CITY OF PORTLAND, MAINE

September 30, 2016

Project Name: Amendment to July 2016 approval
“Station 415” Subdivision and Change of Use/Renovation of Building:
Co-Working Office Unit and four (4) Apartments
Project ID: #2016-196
Address: 415 Cumberland Avenue CBL: 036 G033001
Applicant: Andrew Kraus, M & A Lowcountry Investments, LLC
Planner: Jean Fraser

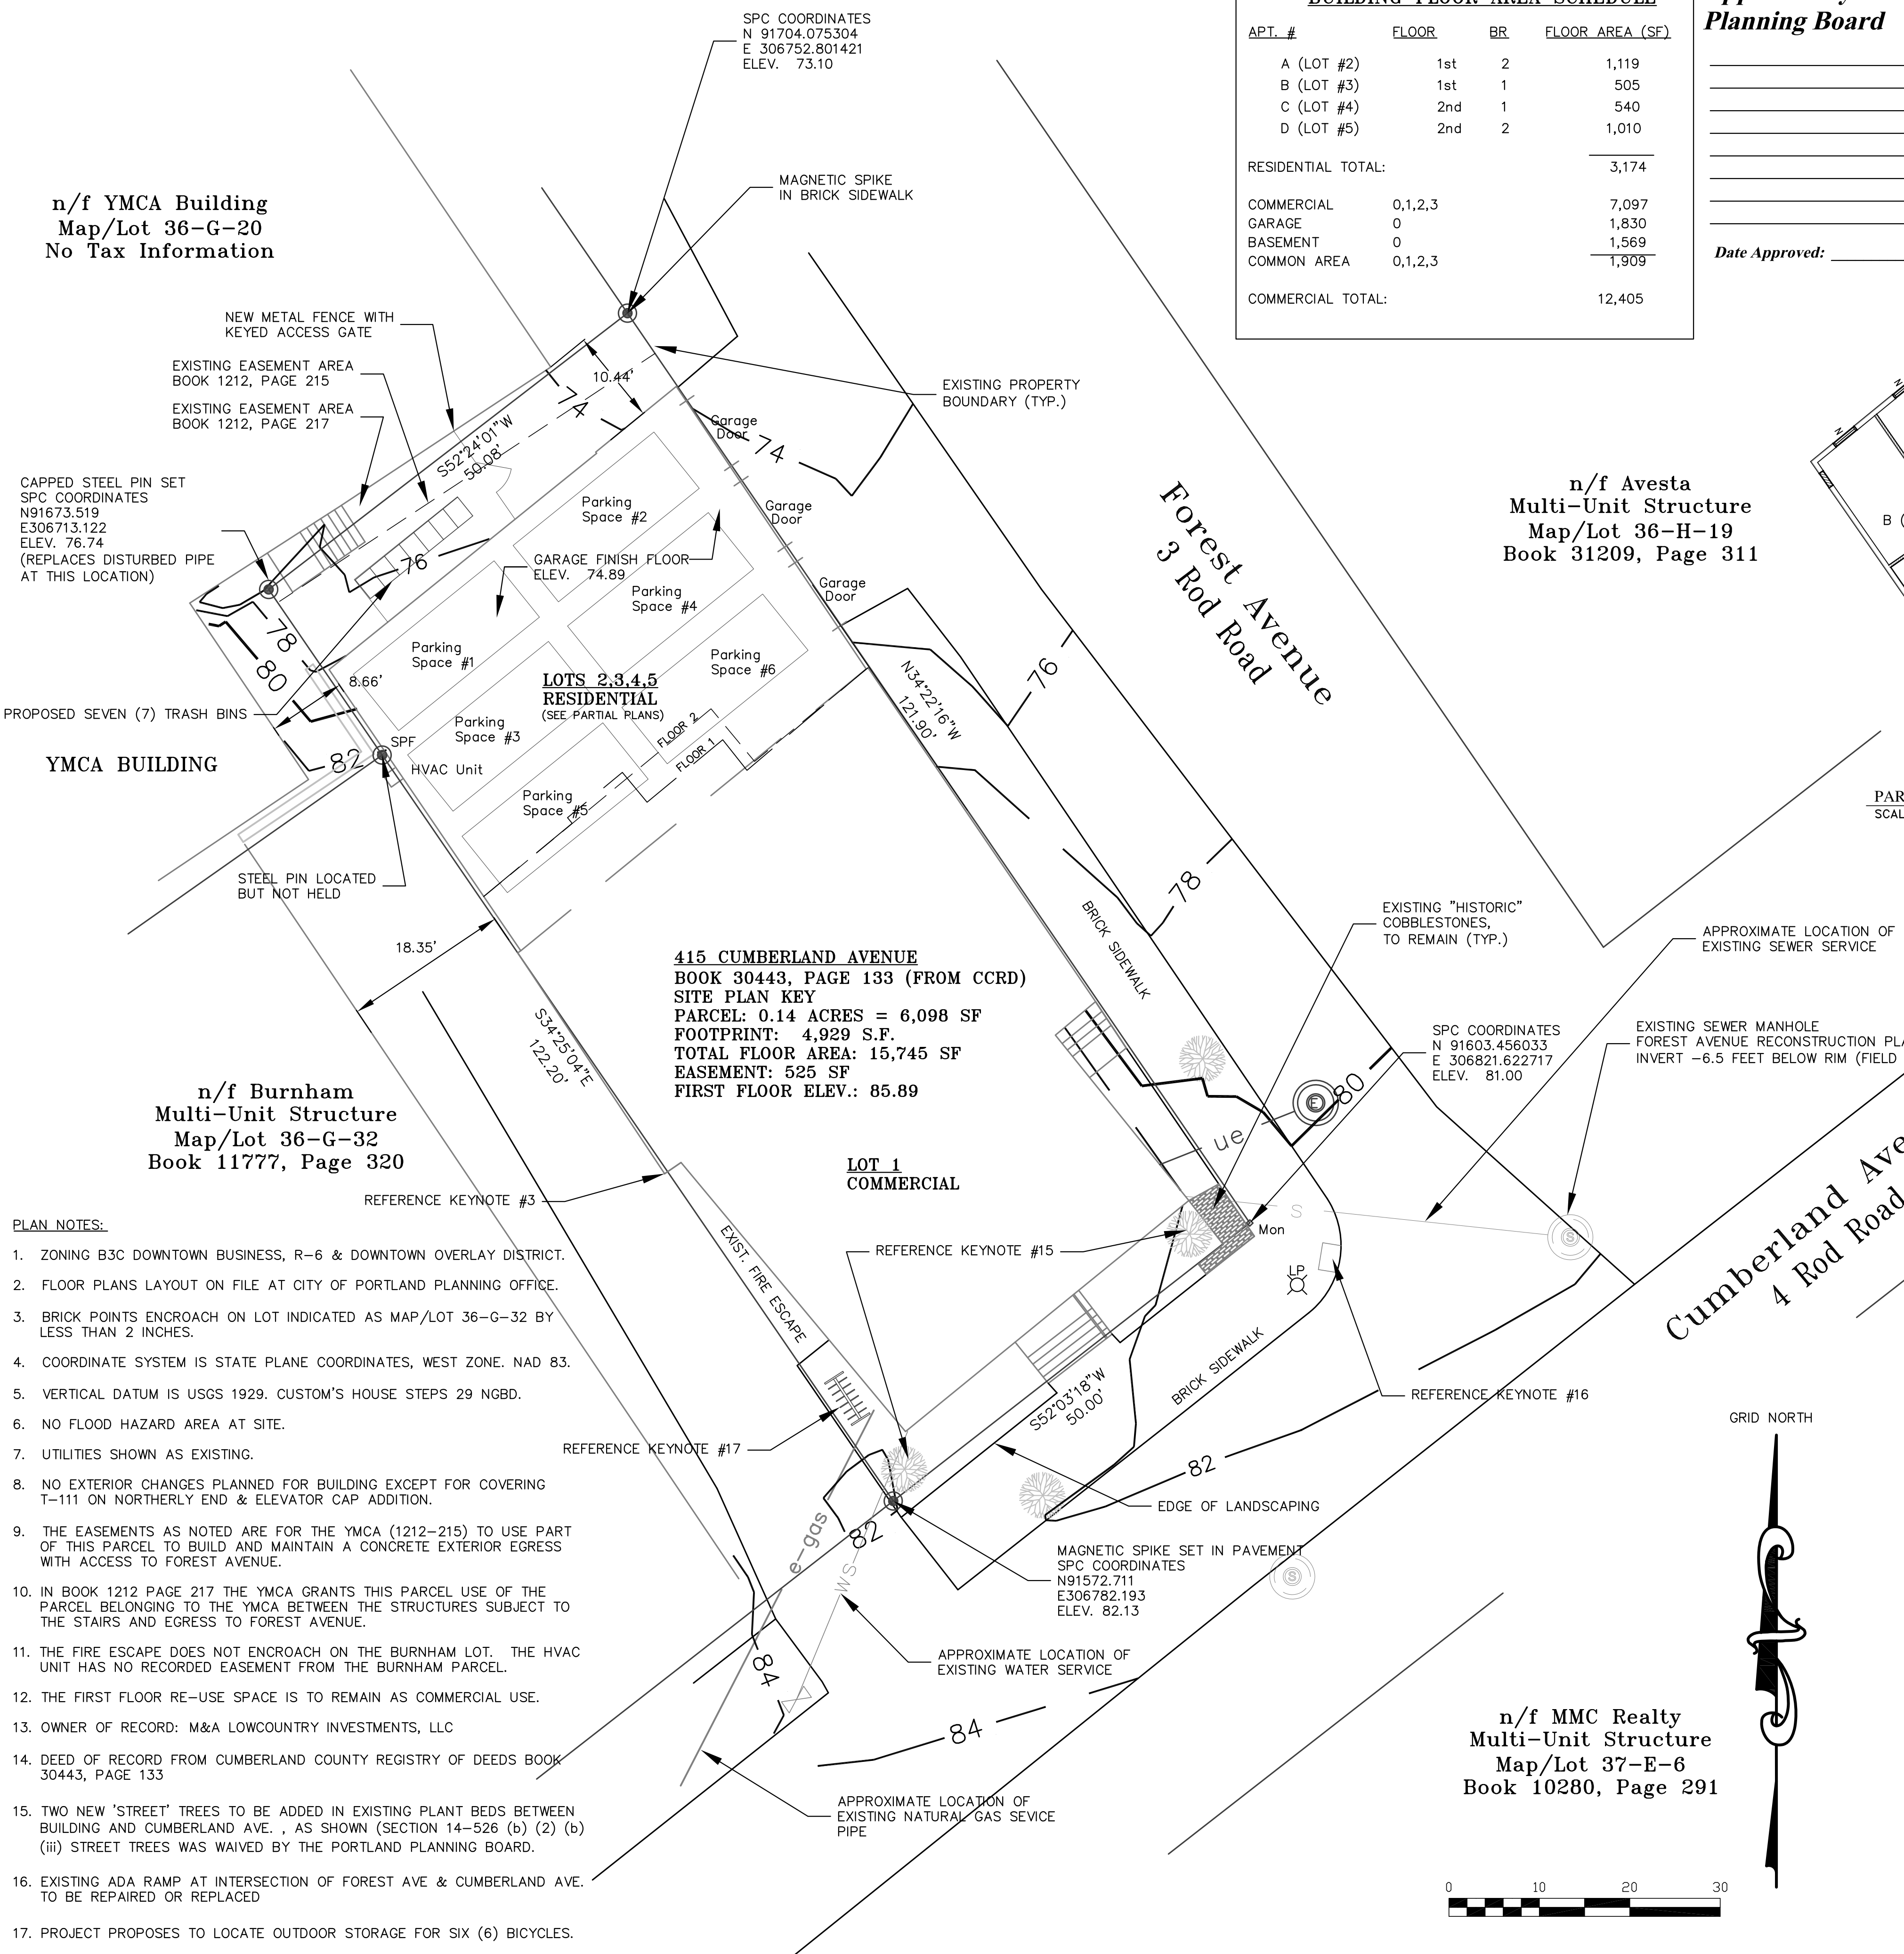
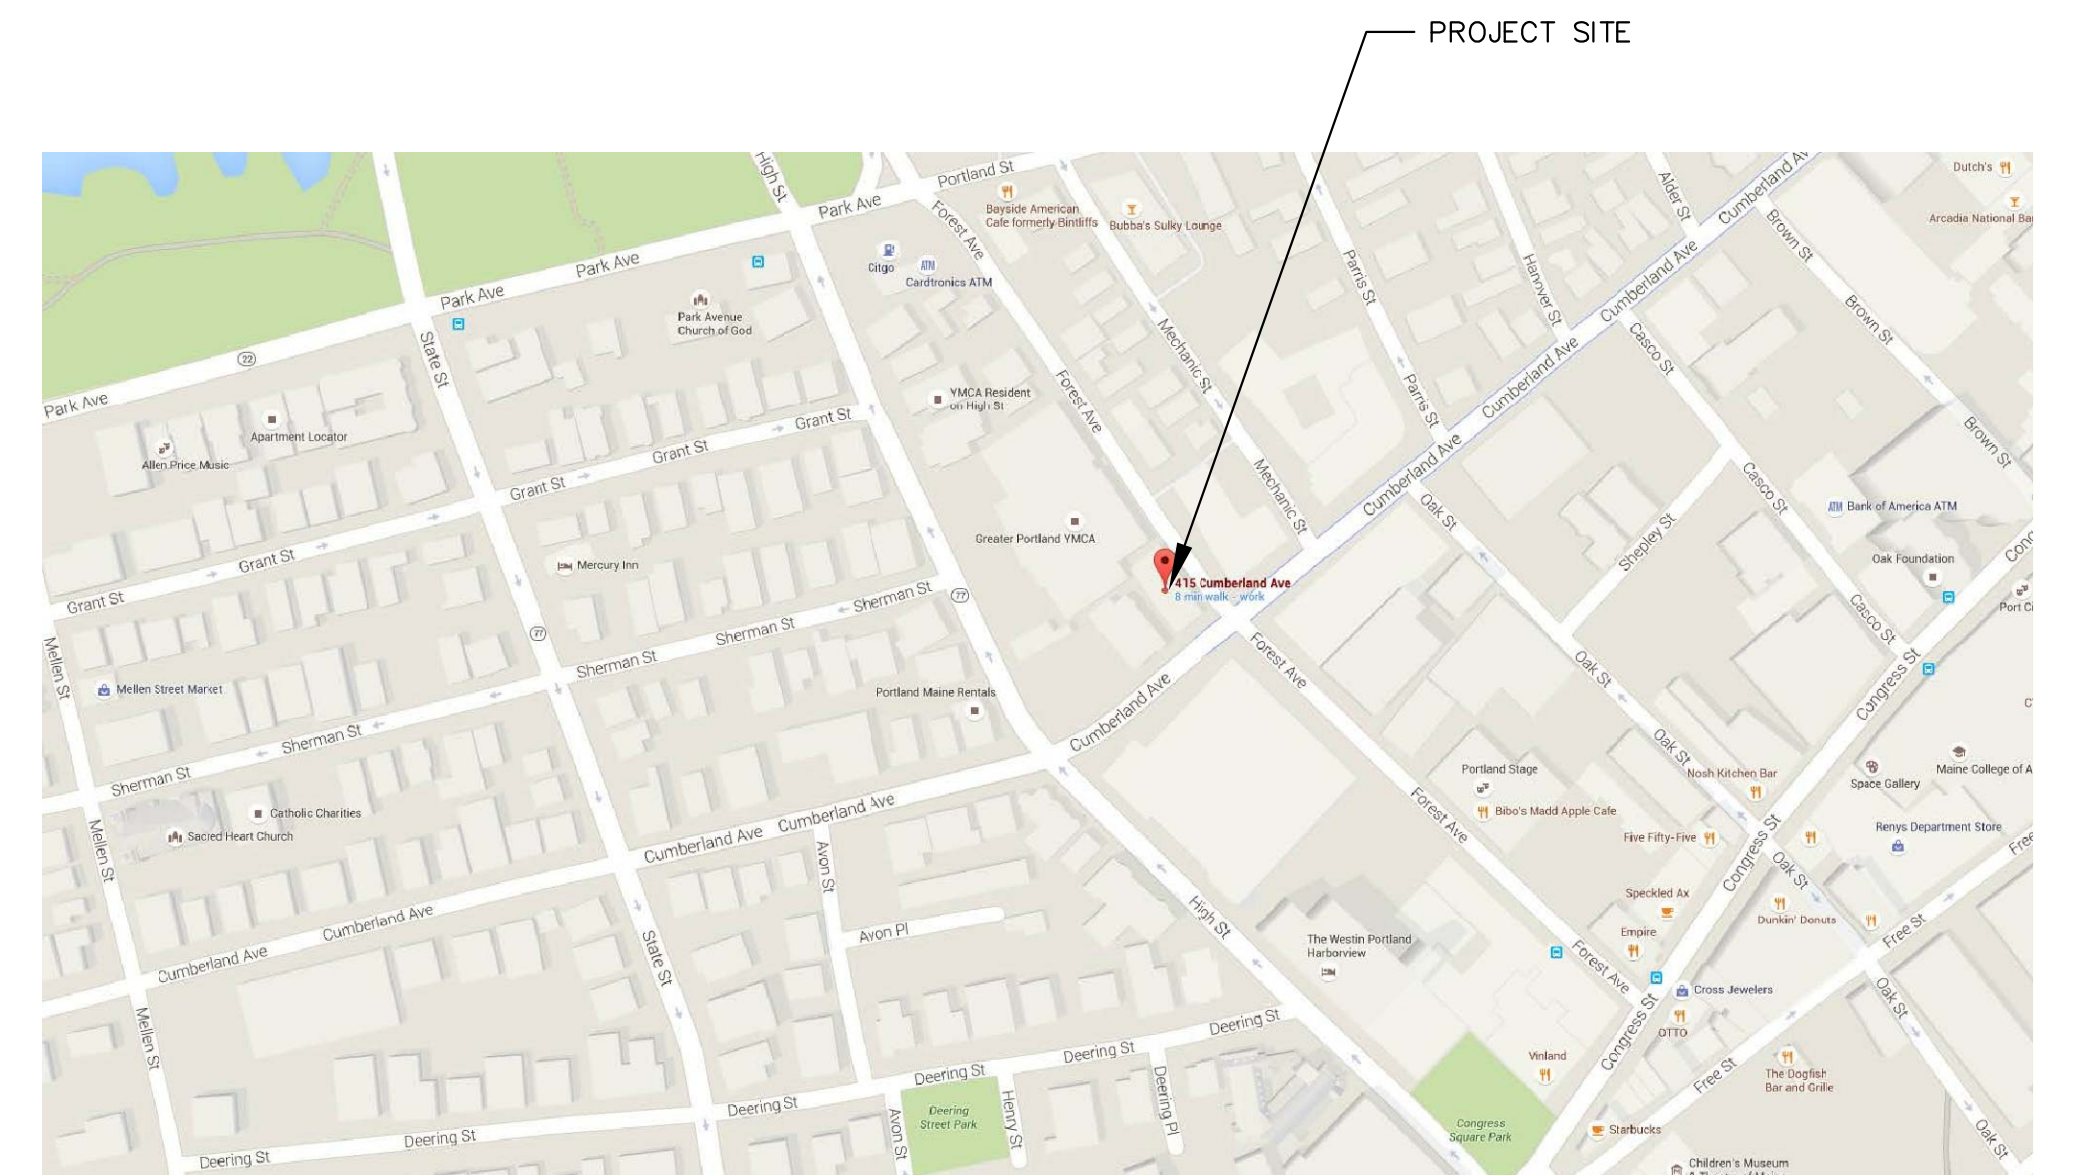
- i. That the Subdivision Plat shall be finalized to the satisfaction of the Planning Authority, Corporation Counsel, and Department of Public Works, prior to submission for Planning Board signature; and
- ii. That in the event the property is converted to a condominium, that the recorded condominium documents shall be copied to the Planning Authority.
